**From:** Contact Centre (CRM) <contact@ribblevalley.gov.uk>  
**Sent:** 26 June 2024 09:34  
**To:** Planning  
**Subject:** Planning Application Comments - 3/2024/0393 FS-Case-625865979

**Planning Application Reference No.:** 3/2024/0393

**Address of Development:** 11 Old Road, Chatburn

TITLE: PLOT 11 - Chaburn Old Rd  
Westerly retaining wall detail

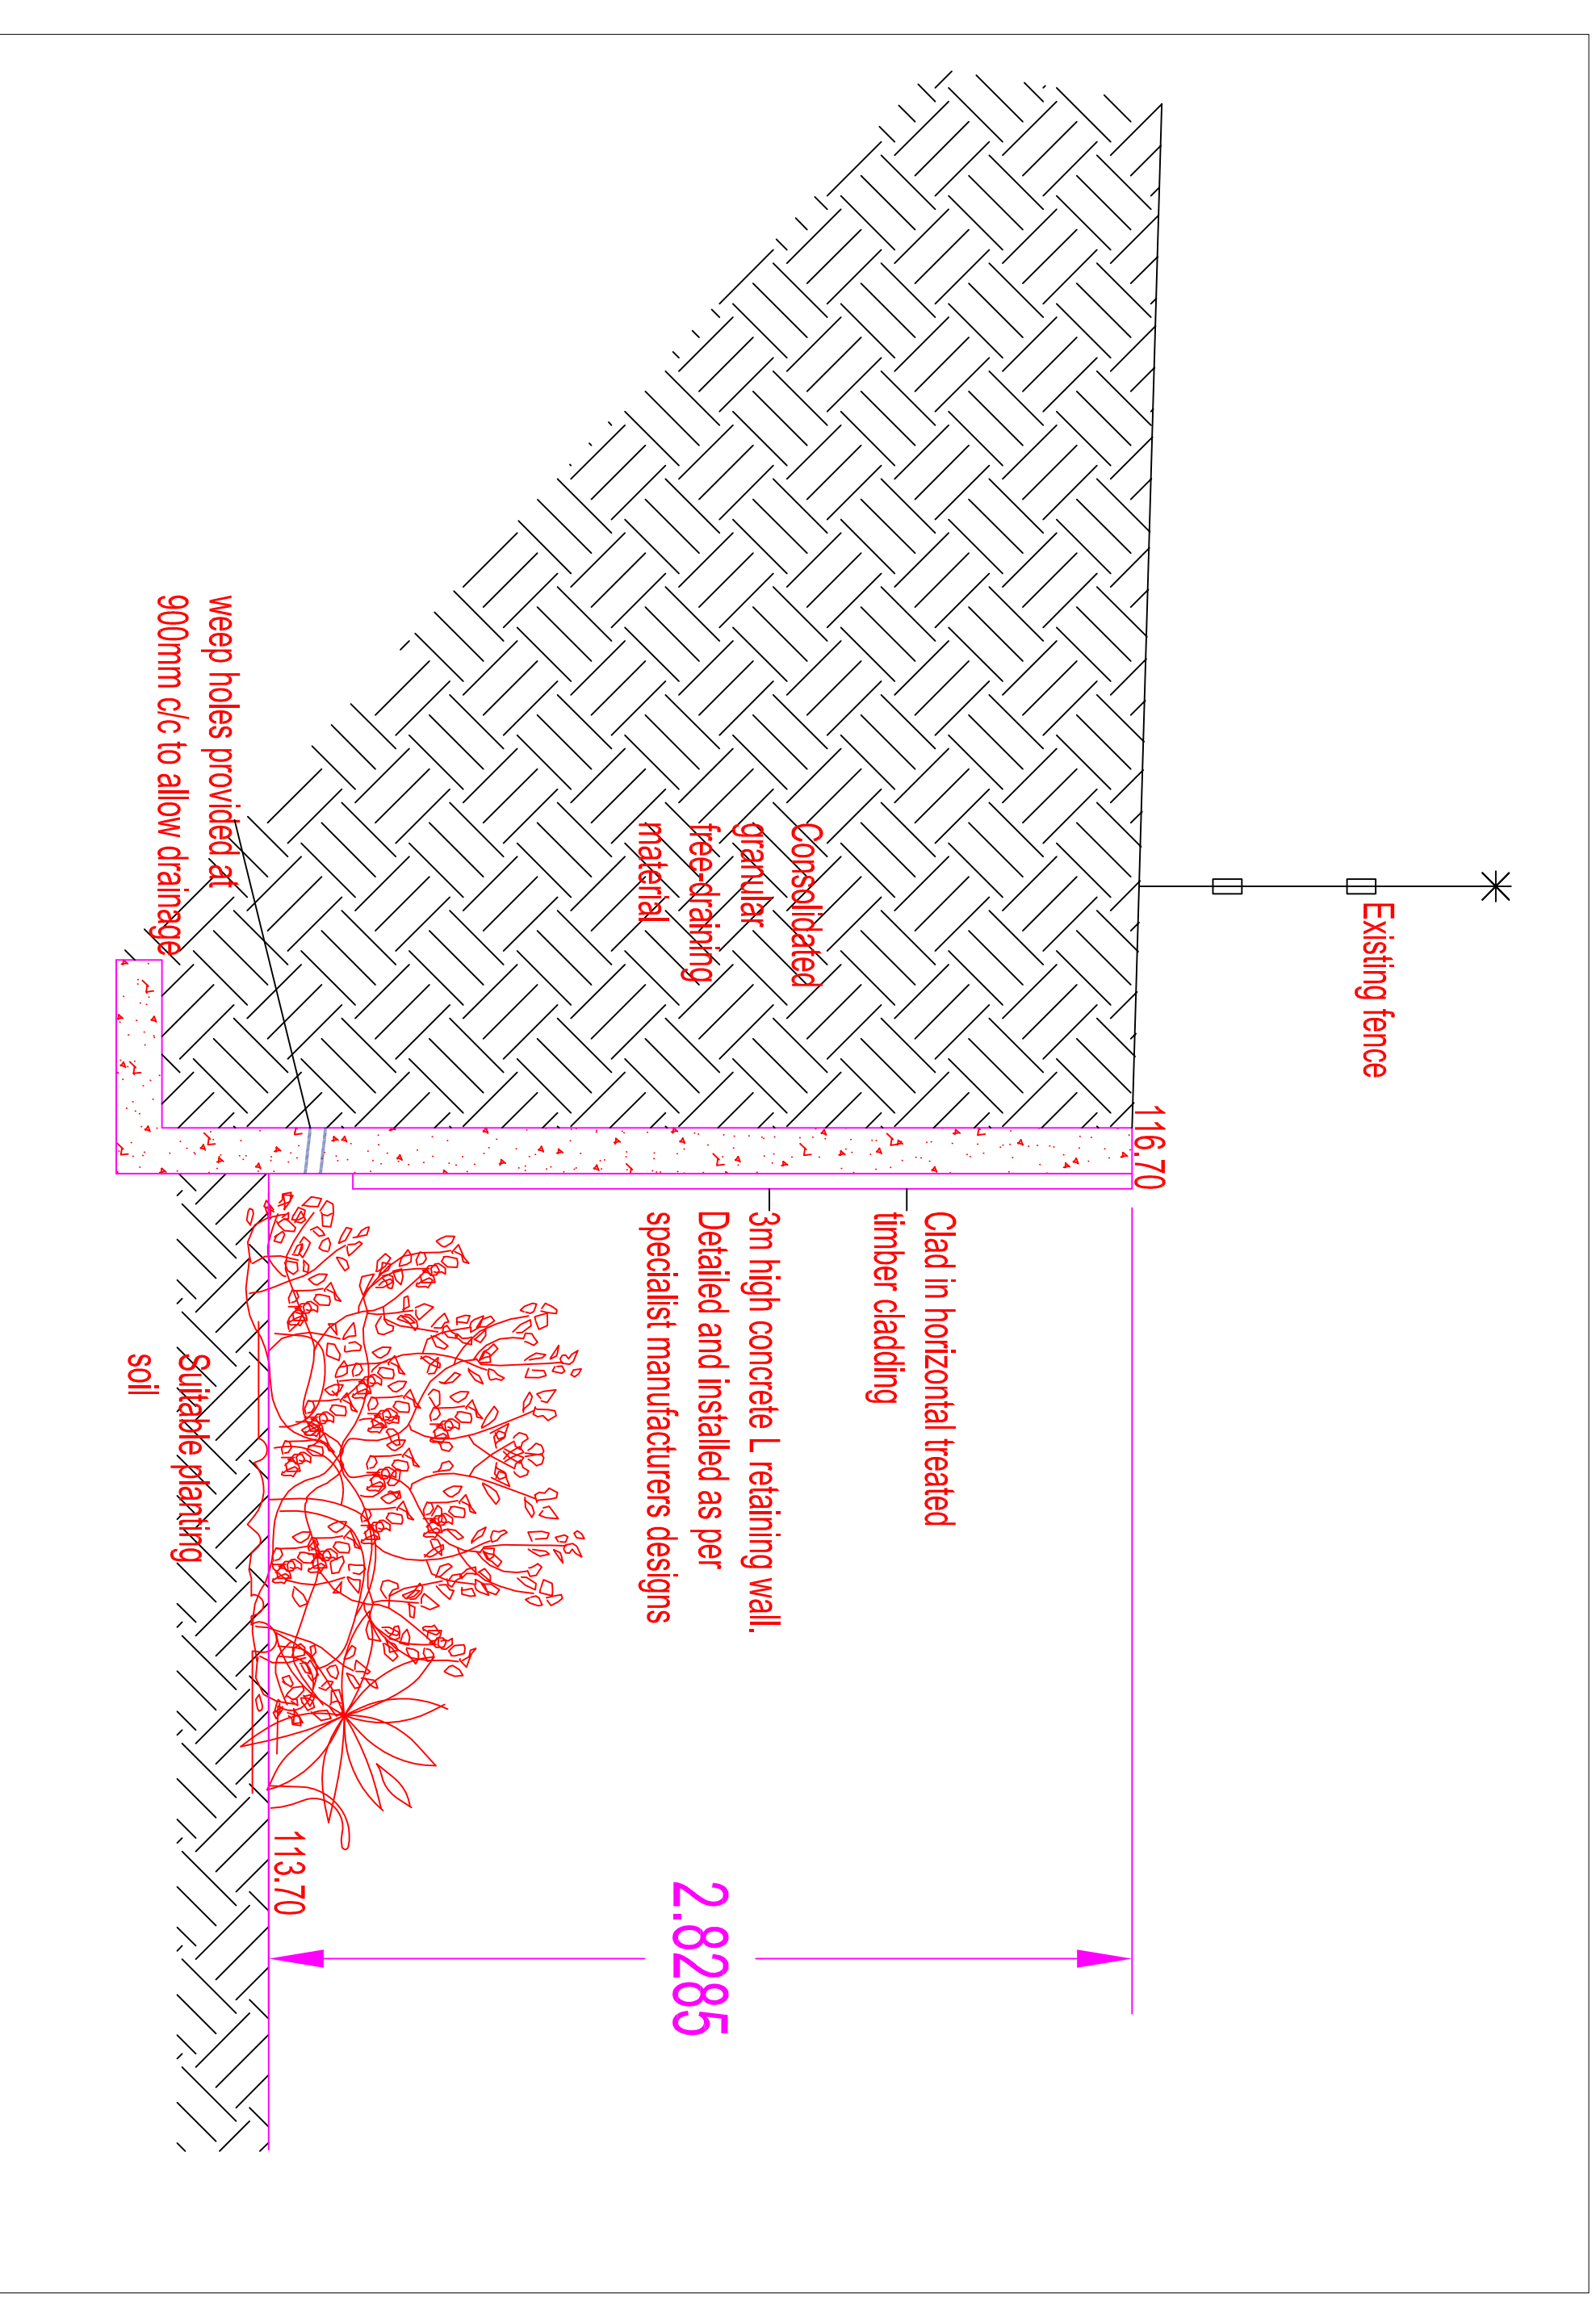
**Comments:** The details of construction of the house and the concrete retaining wall are not fit for purpose and many issues need to be resolved. The 3 mtr high wall would require a massive intrusion into the [REDACTED] and seem inadequate for the support of the land behind, according to a Chartered Engineer [REDACTED]. No permission has been sought or given by the [REDACTED].
